Re: Planning Application No BE/17/18/PL

Mr R Clarke 37 Norbren Avenue, Bognor Regis, West Sussex

I wish to register my objection to the above planning application on the following basis:-

PROJECT	Proposed Bungalow 37 Norbren Avenue, Bognor Regis		
TITLE	Proposed Ground and First Floor Plans		
CLIENT	Mr & Mrs Clarke		
SCALE	1: 100	DATE	16/09/2017
DRAWING NO.	906-01	rev.	.

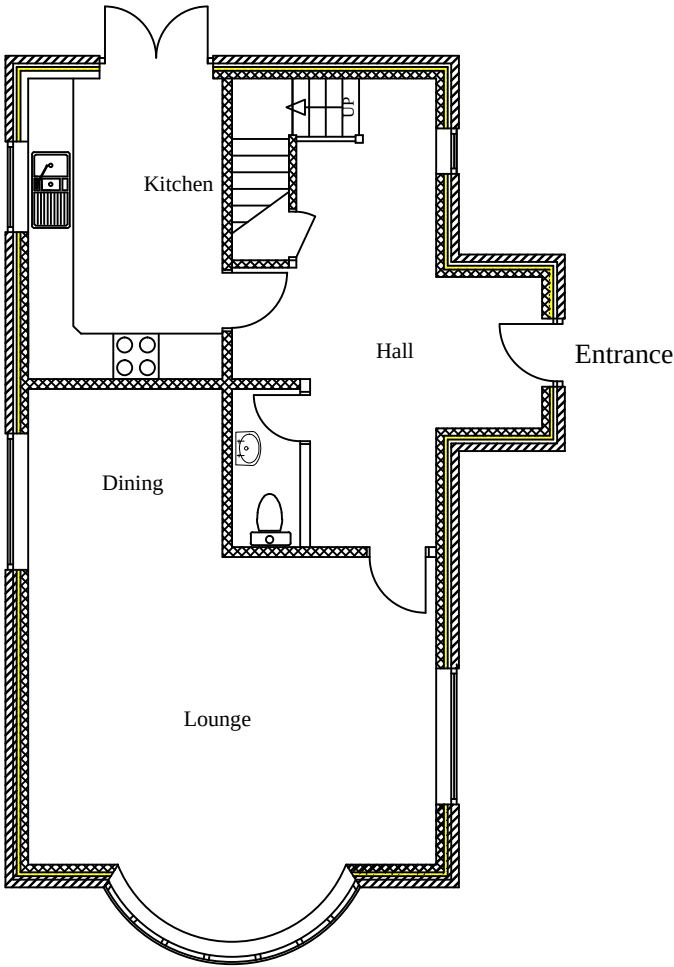
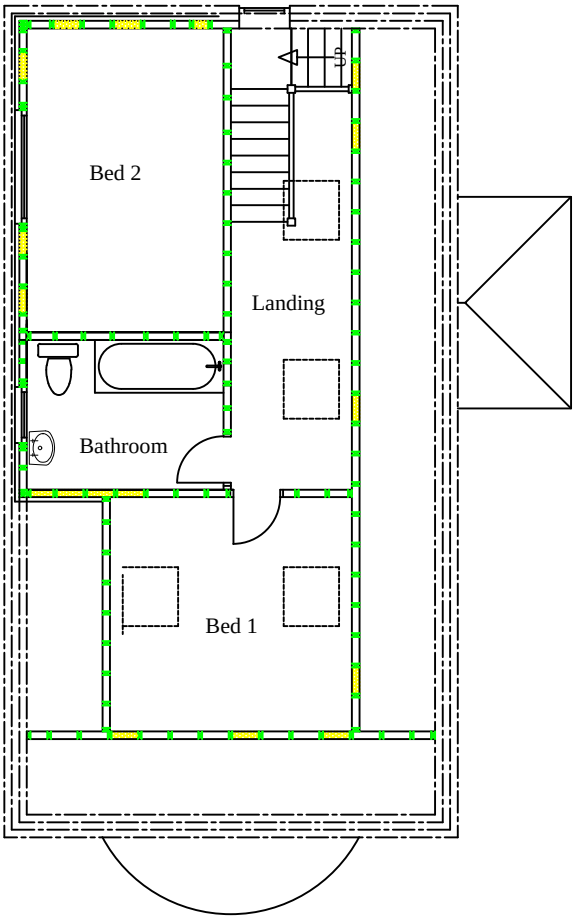
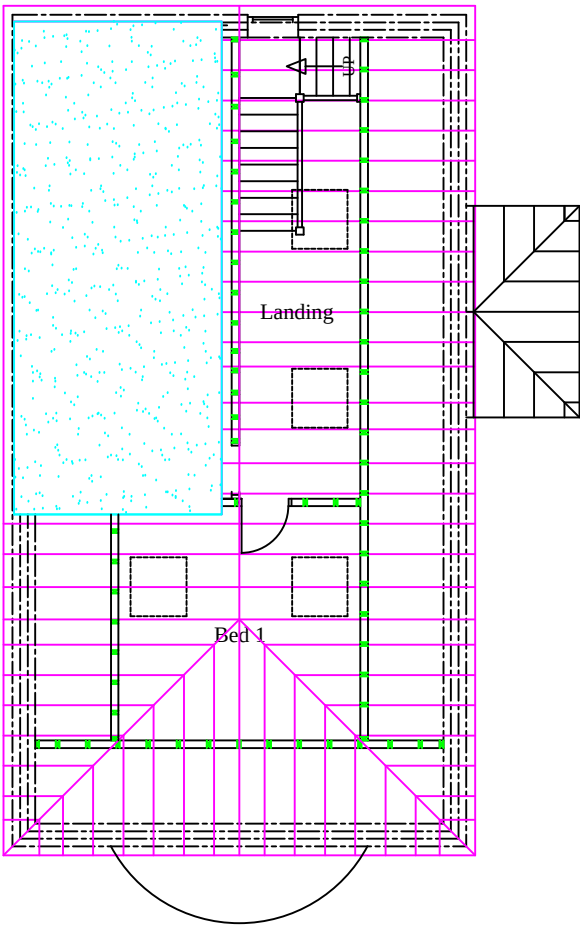
2. As most homes usually have 2 vehicles there will be added congestion with this proposed development and an accident waiting to happen with a car pulling out of the proposed new property driveway into Norbren Avenue on that corner.

4. There is no way the proposed chalet bungalow is in keeping with the surrounding area. They are all 1930s houses in the surrounding roads. In addition, from the plan it shows the bungalow totally out of the building line with the other houses.
